Re: Inspection Item
Location: Lot 88 Seagrass Landing (44 Kidnees Dr. (Lillington, NC))
JDS Project No.: RDU2510575
Date of Inspection: 10/13/2025

Observations

SLAB FOUNDATION PLAN - FRENCH COUNTRY

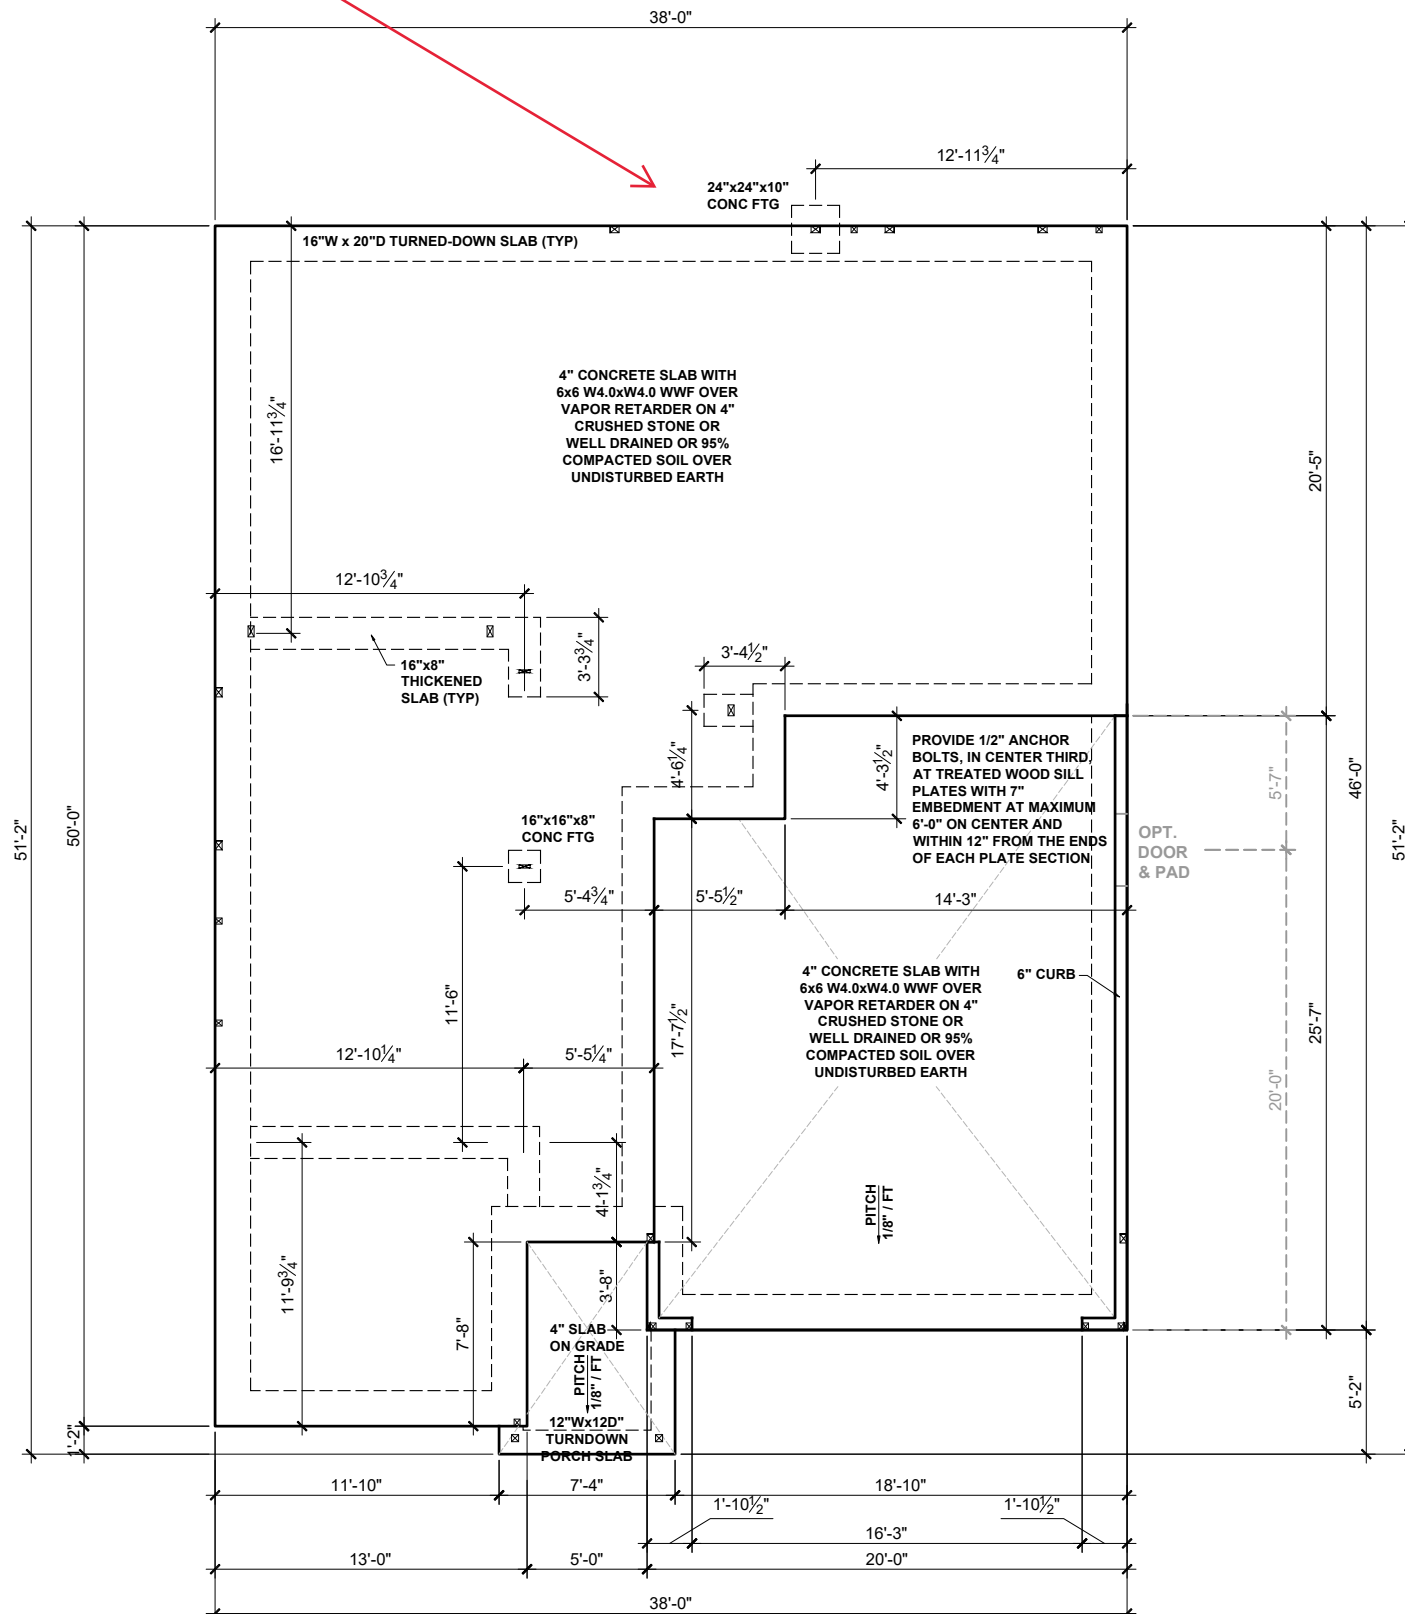
The client requested an evaluation of the 2x4 sill plates installed along all exterior walls (front, right, rear, and left). It was noted that the sill plates extend beyond the edge of the foundation by approximately 1/4 inch to 3/4 inch in various areas.

Based on our on-site observations and review, the 2x4 sill plates have adequate bearing for the anticipated loading conditions as installed. No further action is required.
